BP#2016-01901 49 Hancock Street

Please review the attached revision per your comments.

Summary:

**COV**

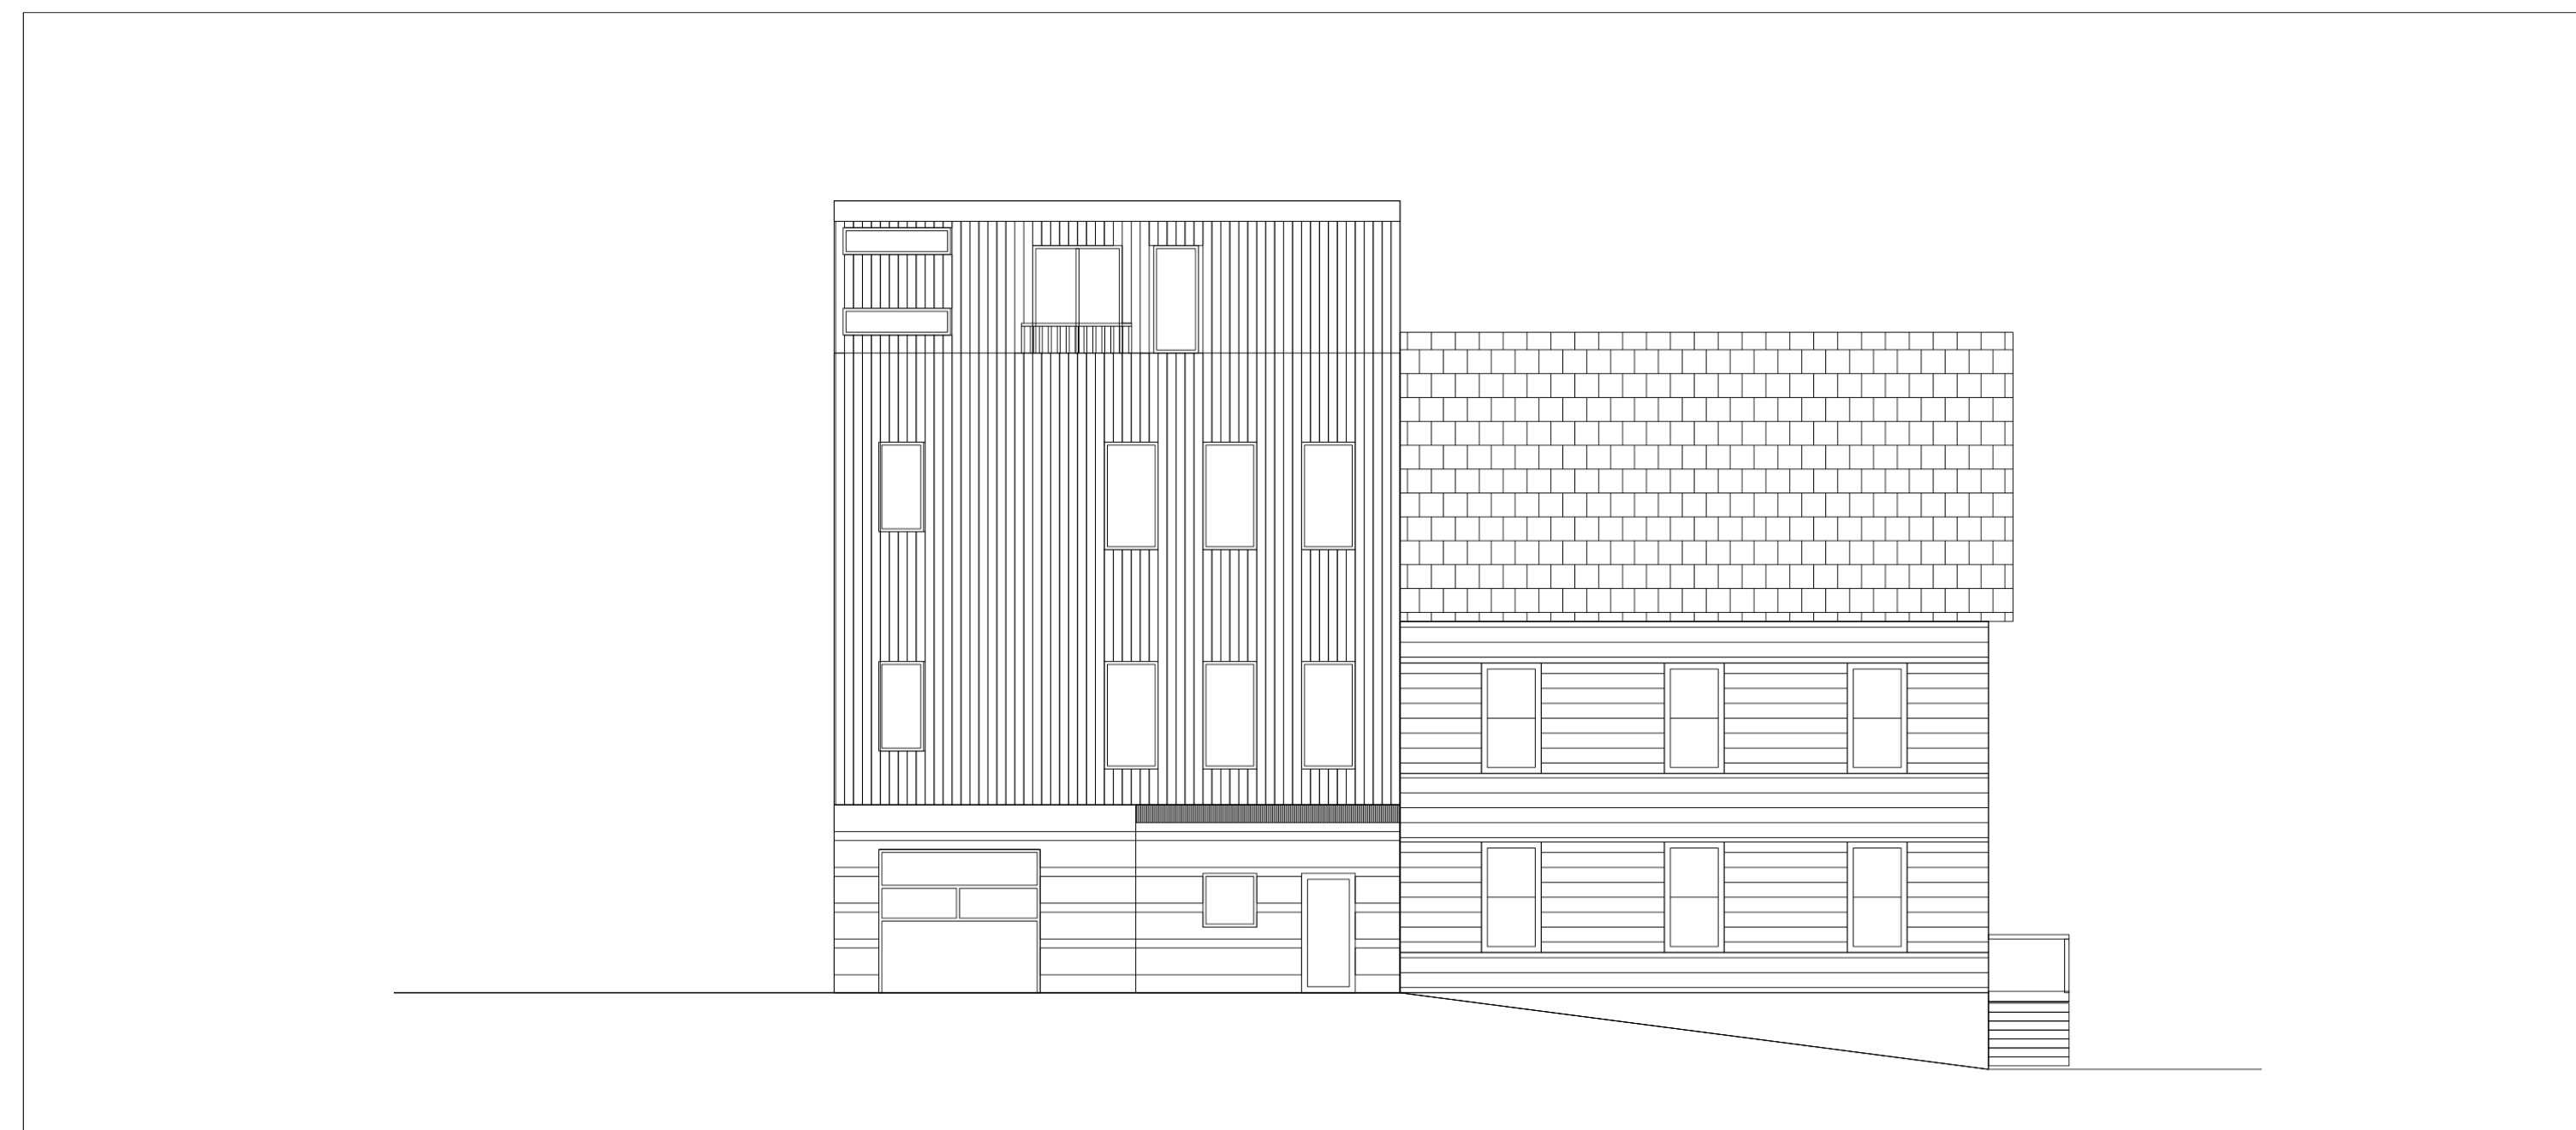
1. 1.0 Cover Sheet: Occupant load number rounded up.
2. A1.1 "Flame OFF" cut sheet attached with this email. The cut sheet shows fire rating with the paint thickness needed to apply.

Drawing file: 1.  Original Plans / S1.1 - Framing Plans.pdf

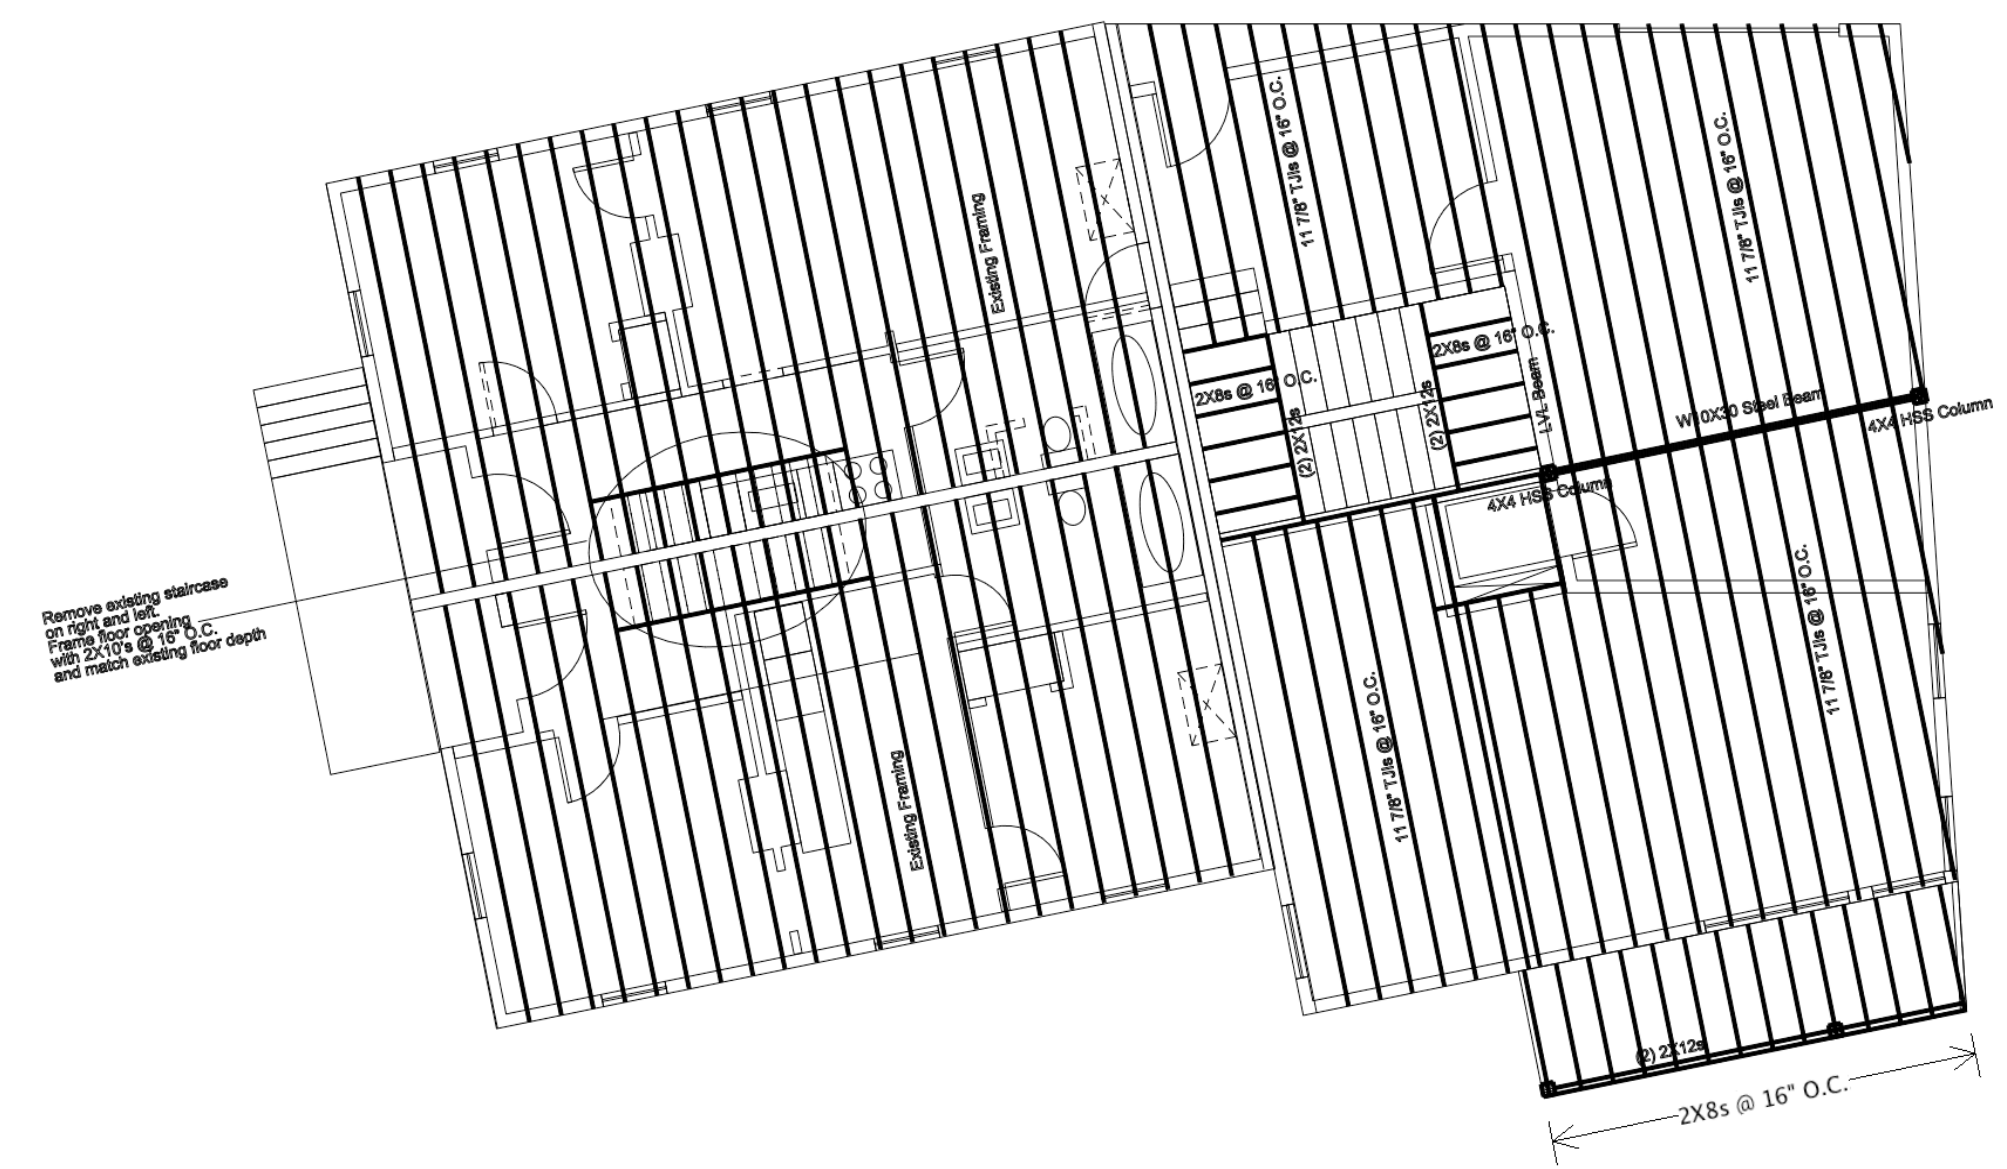
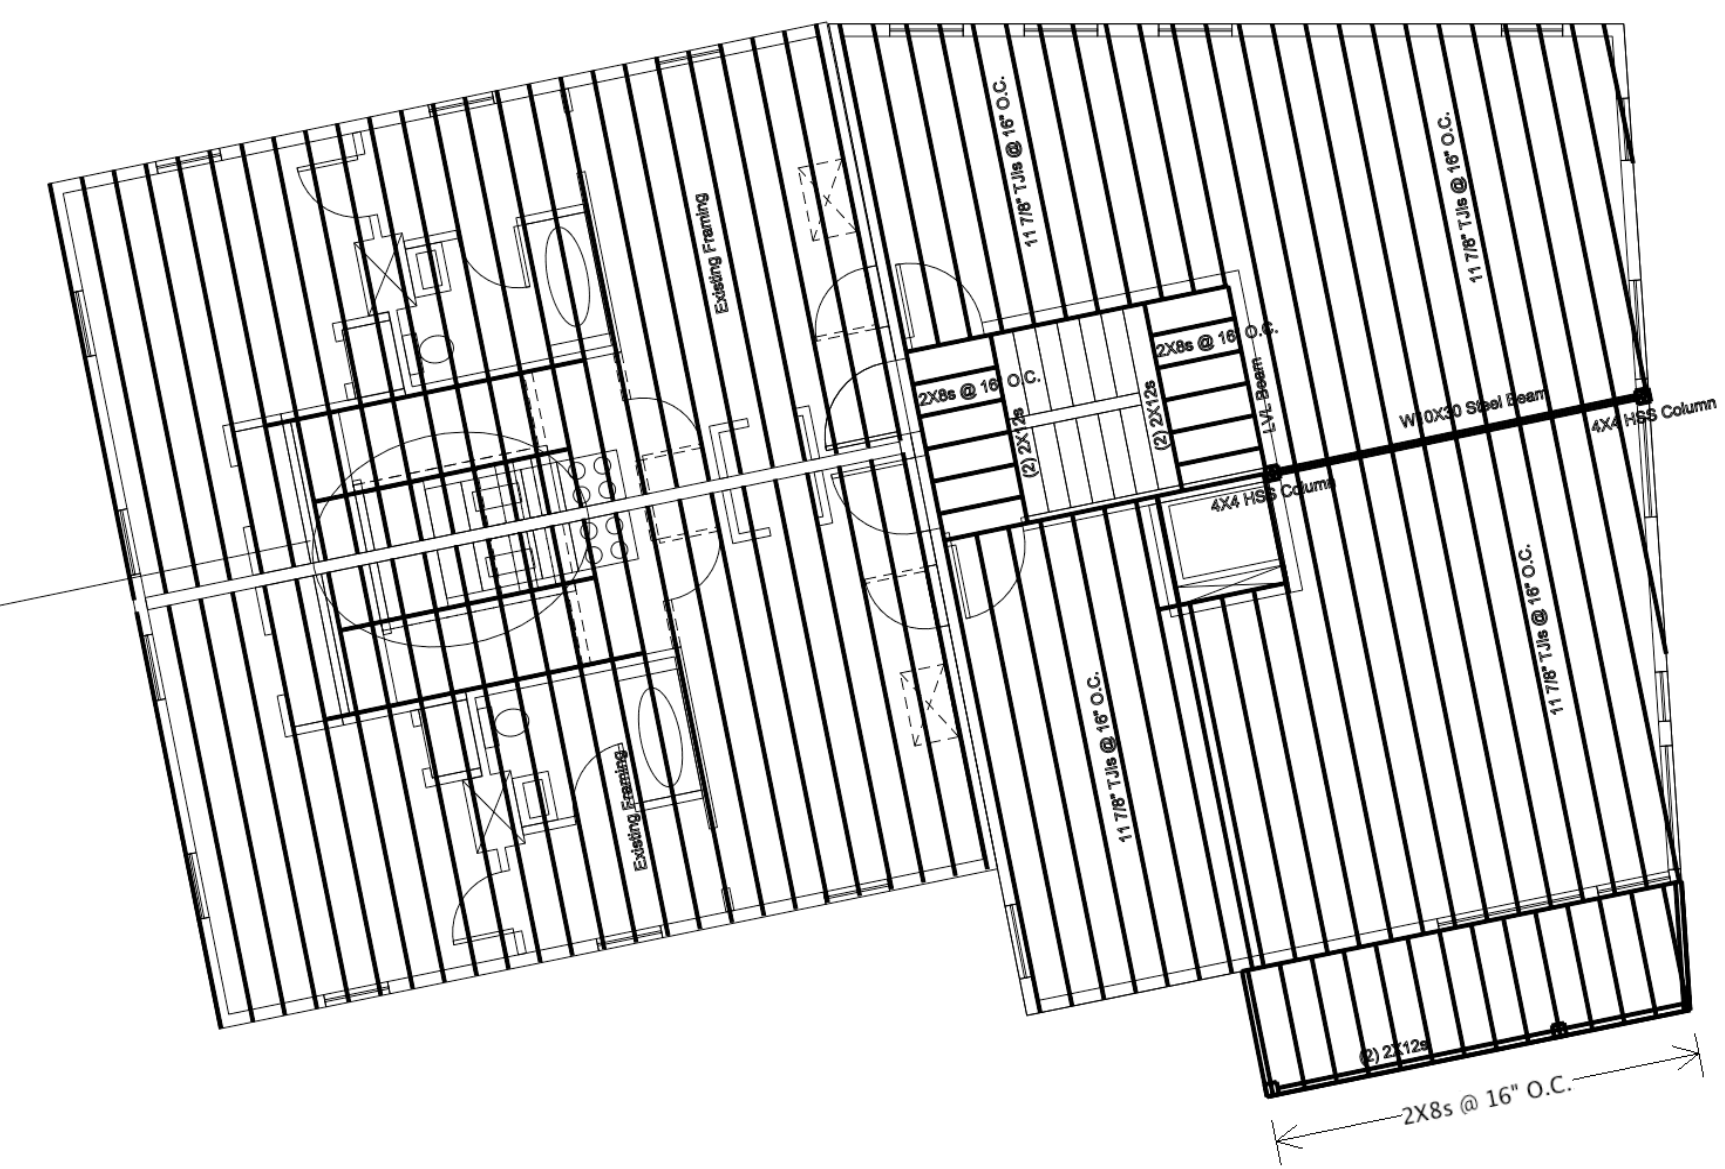
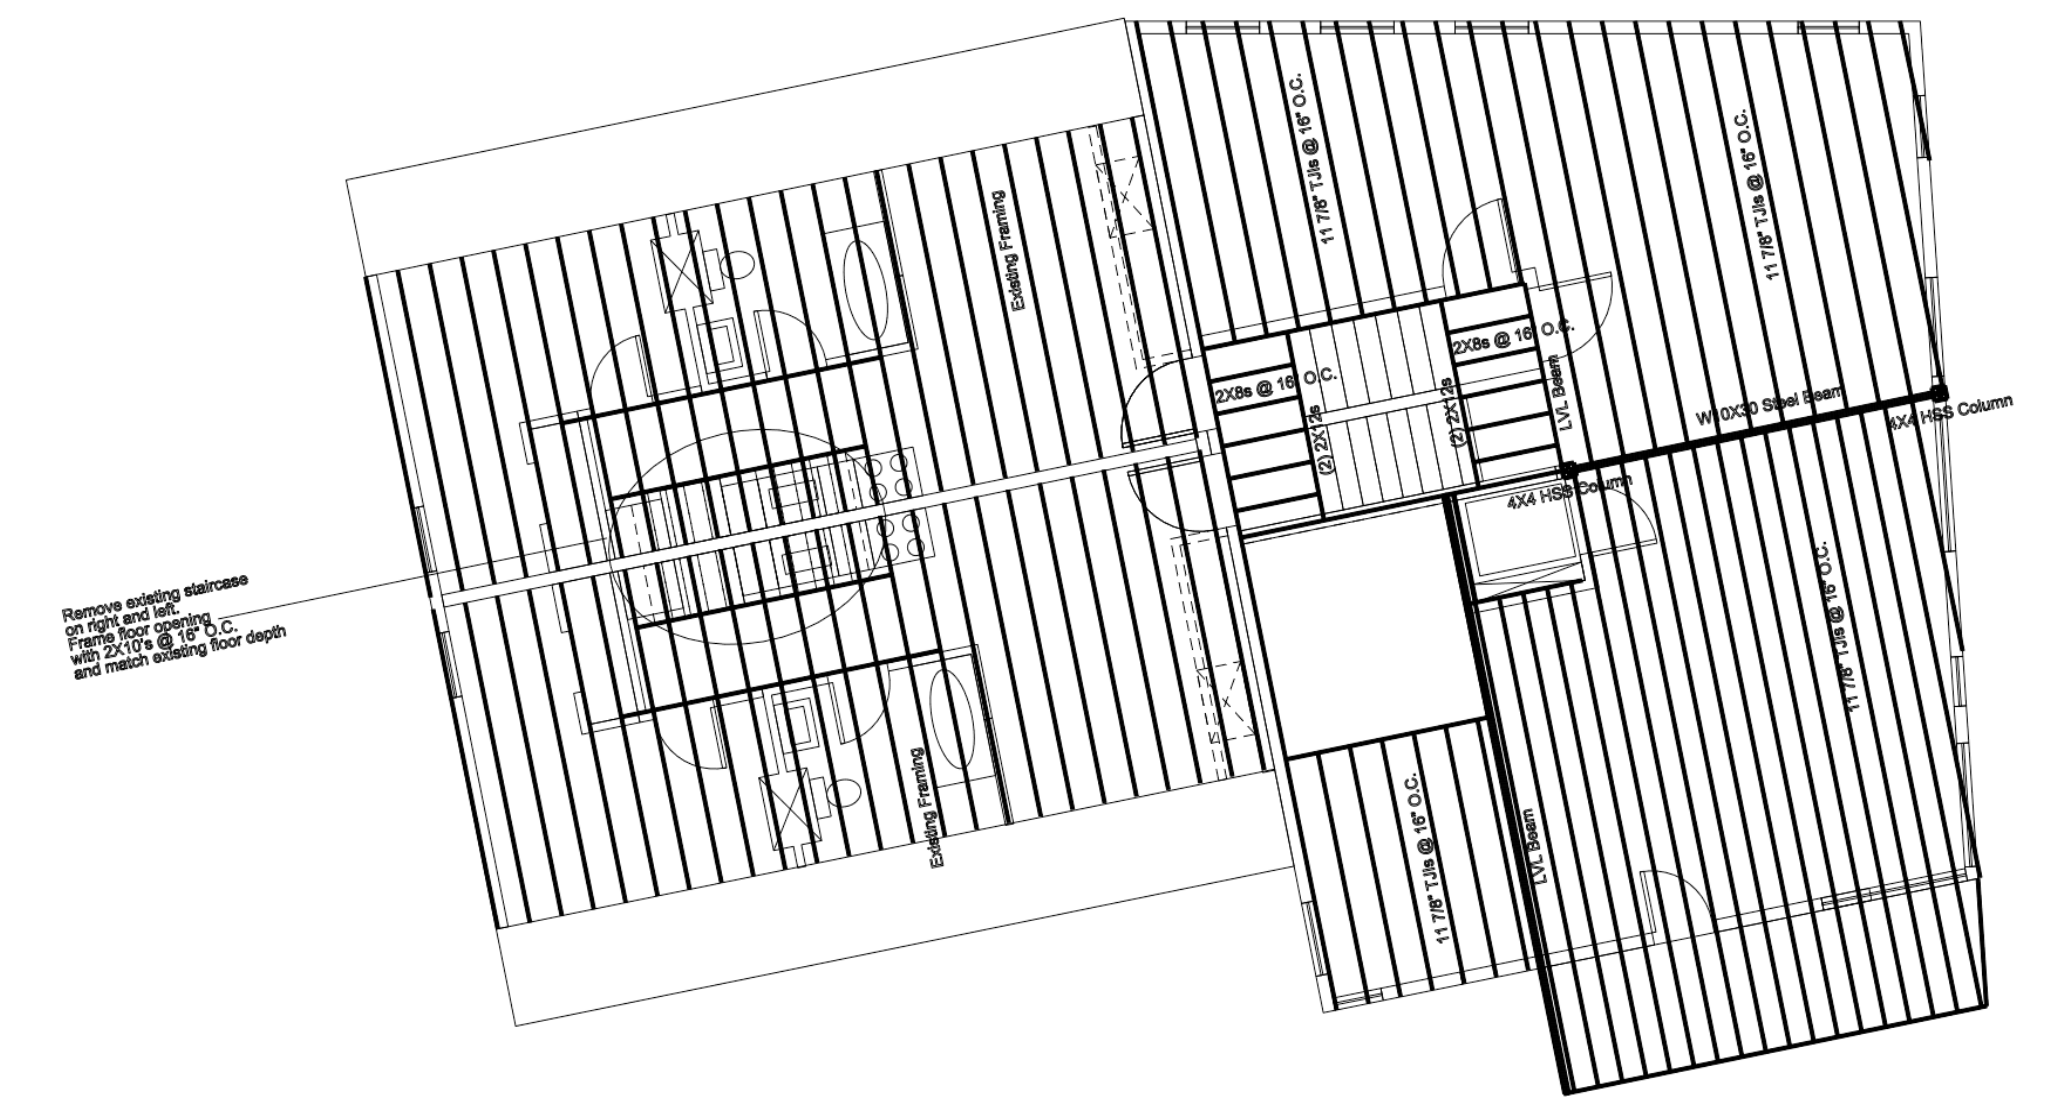
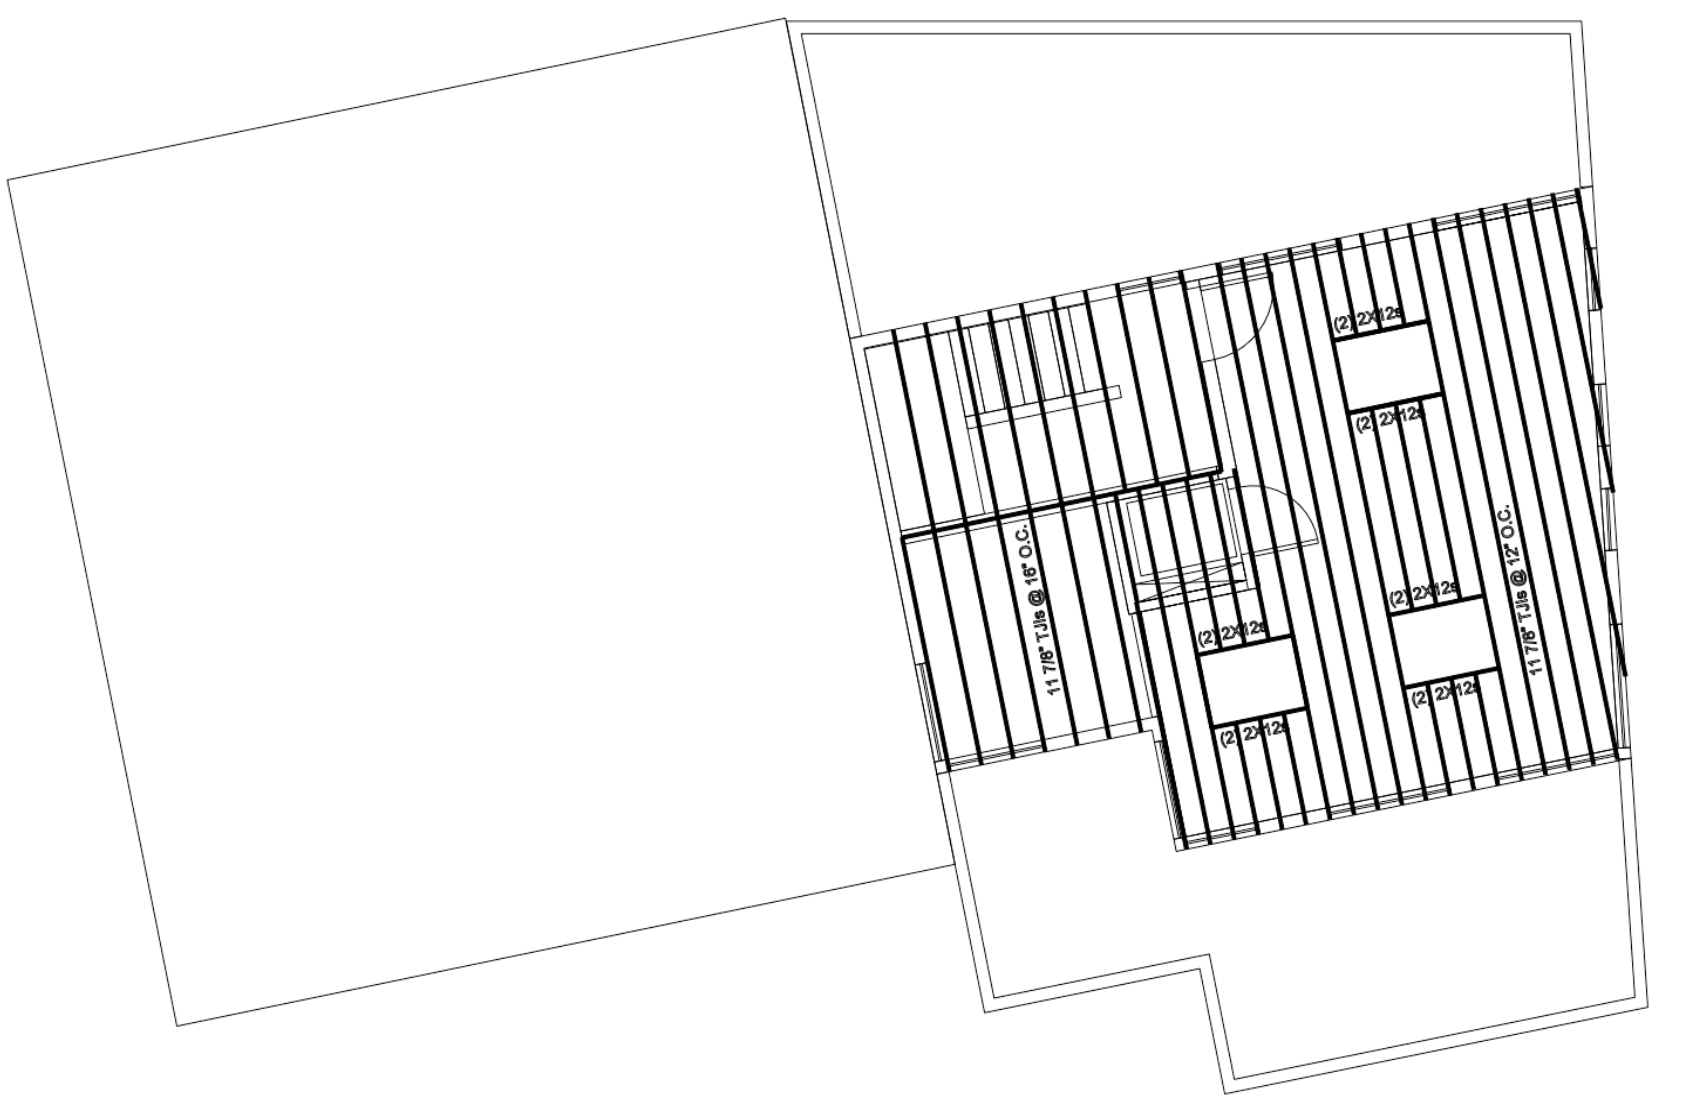
8. S1.1 Foundation added for deck posts. Deck posts to be steel posts.
